Please ask for: Sian Eggington
Email: sian.eggington@terraquest.co.uk
Telephone: 0121 2341390
Our Ref: M/59/20/HH
Your Ref:
Date: 12th August 2020

Application for Planning Permission for Works or Extension to a Dwelling

Development: Extension and remodelling of existing dwelling with a new top storey, front, rear and side extensions. New garden store to rear, new garage to front.
Location: 56 Southdean Drive Middleton-On-Sea PO22 7TB

DRAWING TITLE **Proposed Site Plan**

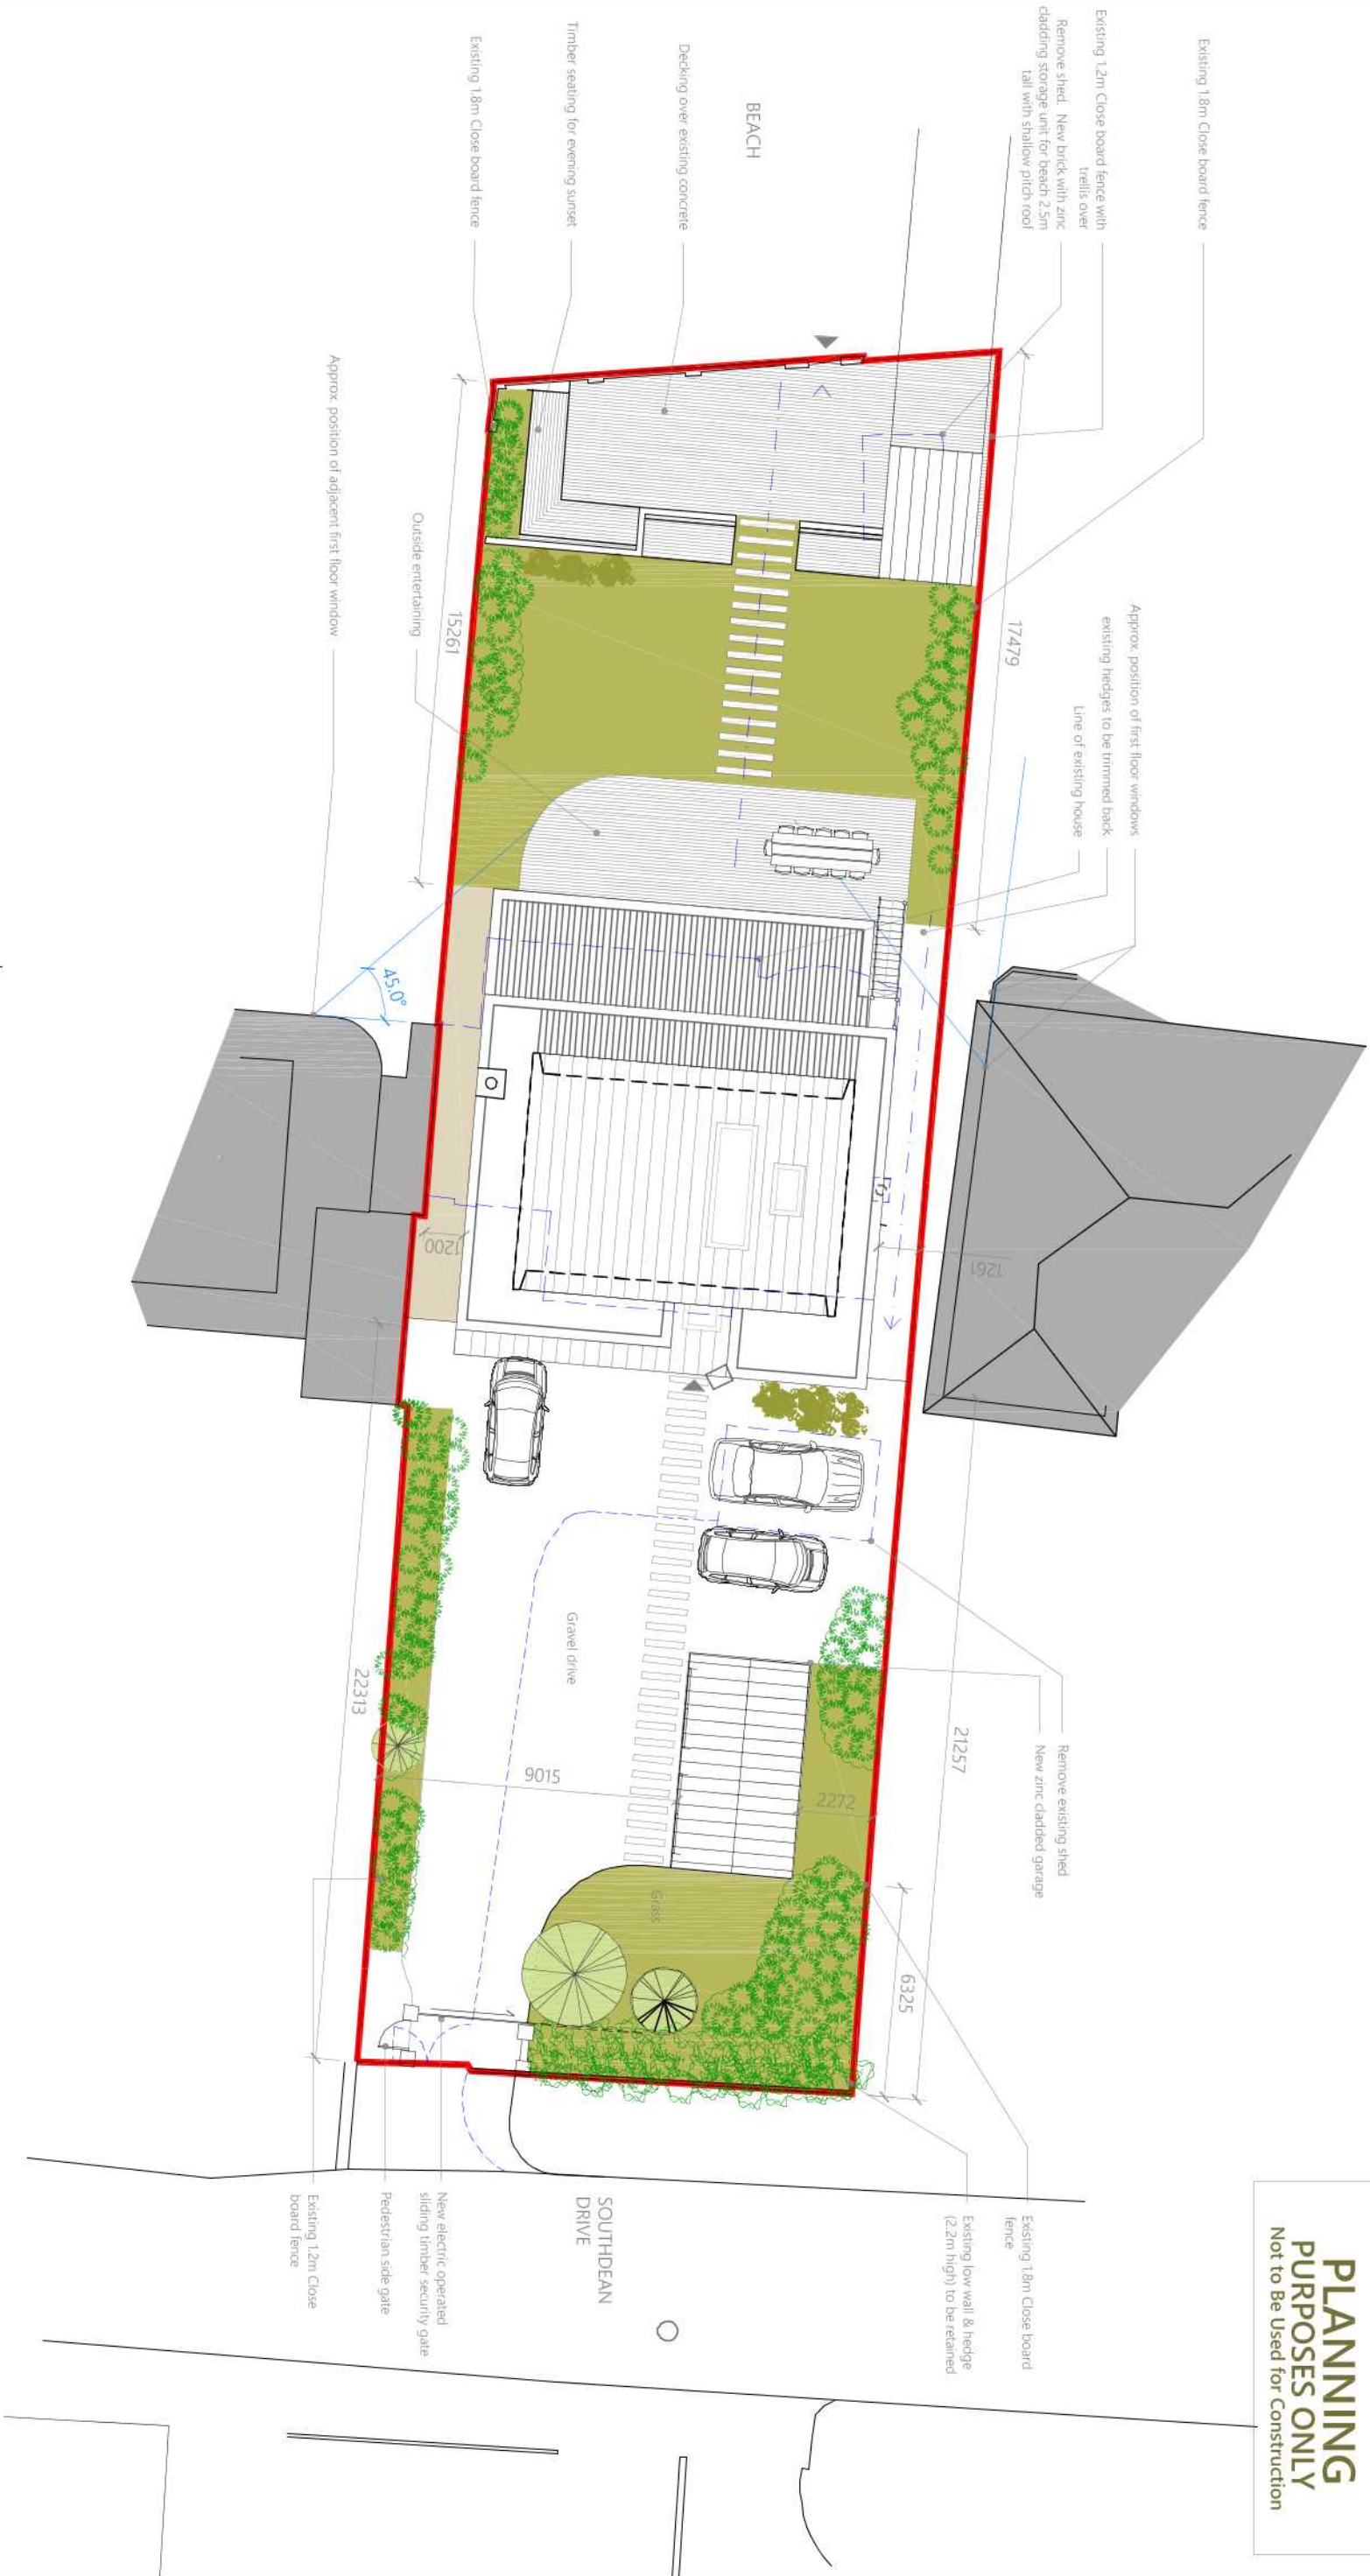
Block Plan: You are required to include dimensions from the proposed extension to all site boundaries. Please amend.

CLIENT **Mark & Melissa Muscat**
PROJECT **56 Southdean Drive**
DRAWING TITLE **Proposed Outbuildings**

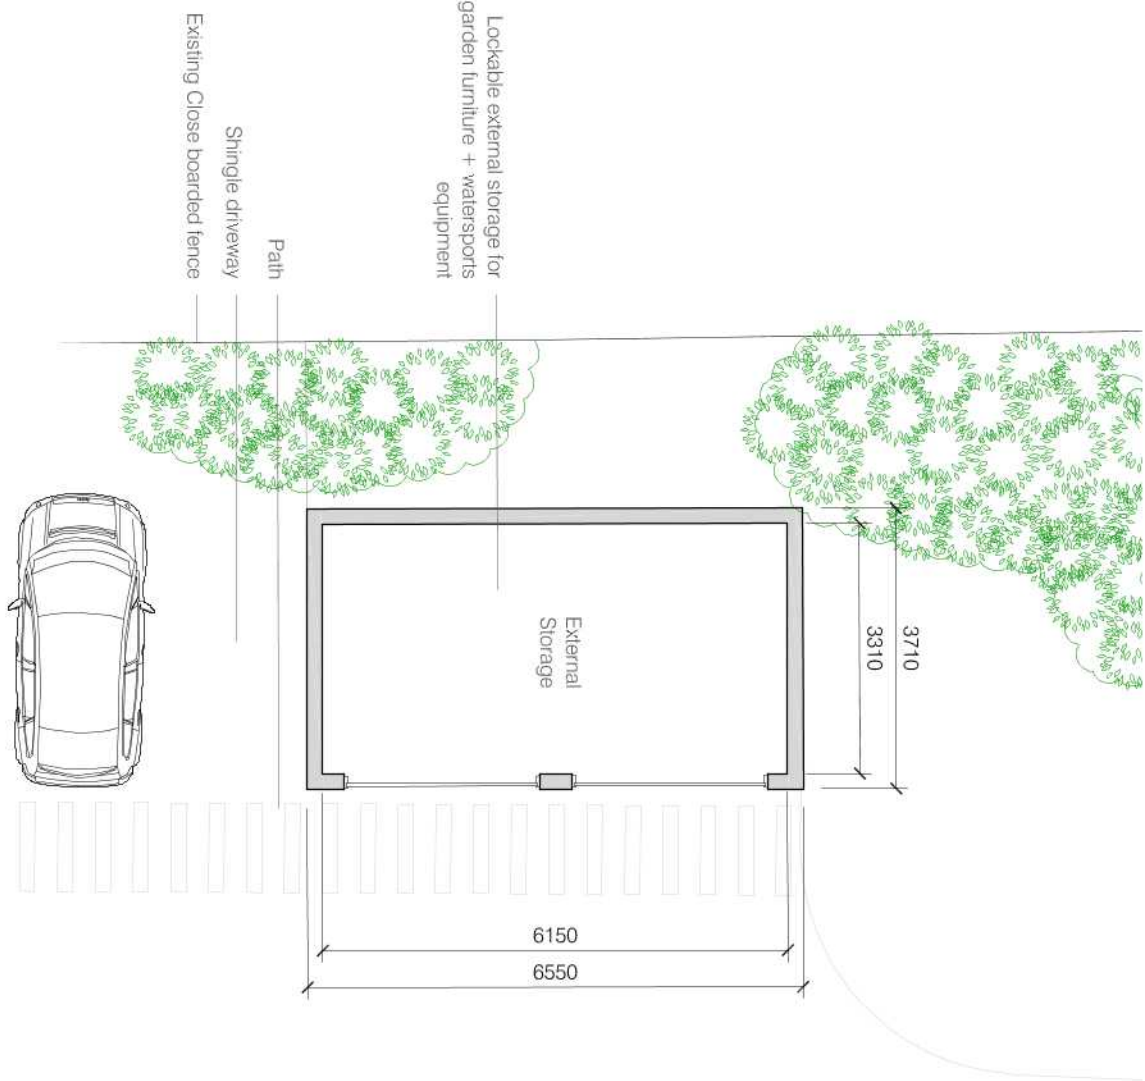
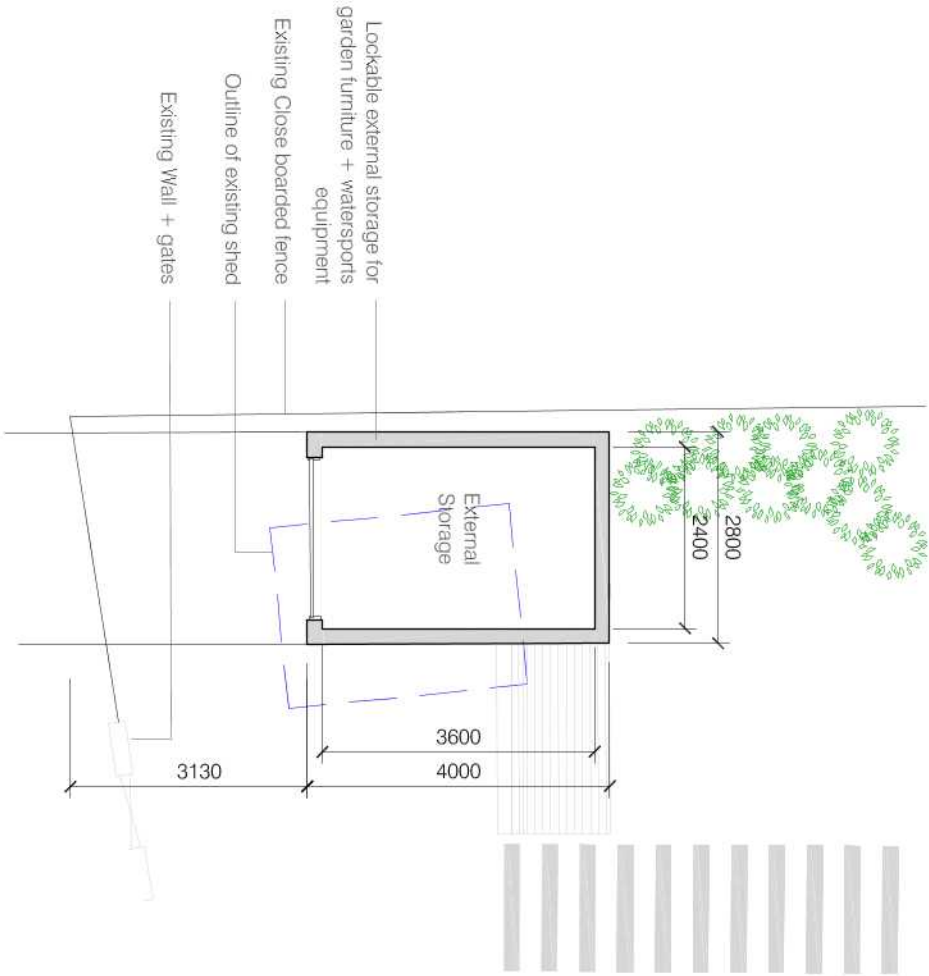
Room Label: Please add a room label to the outbuilding to show the proposed use.
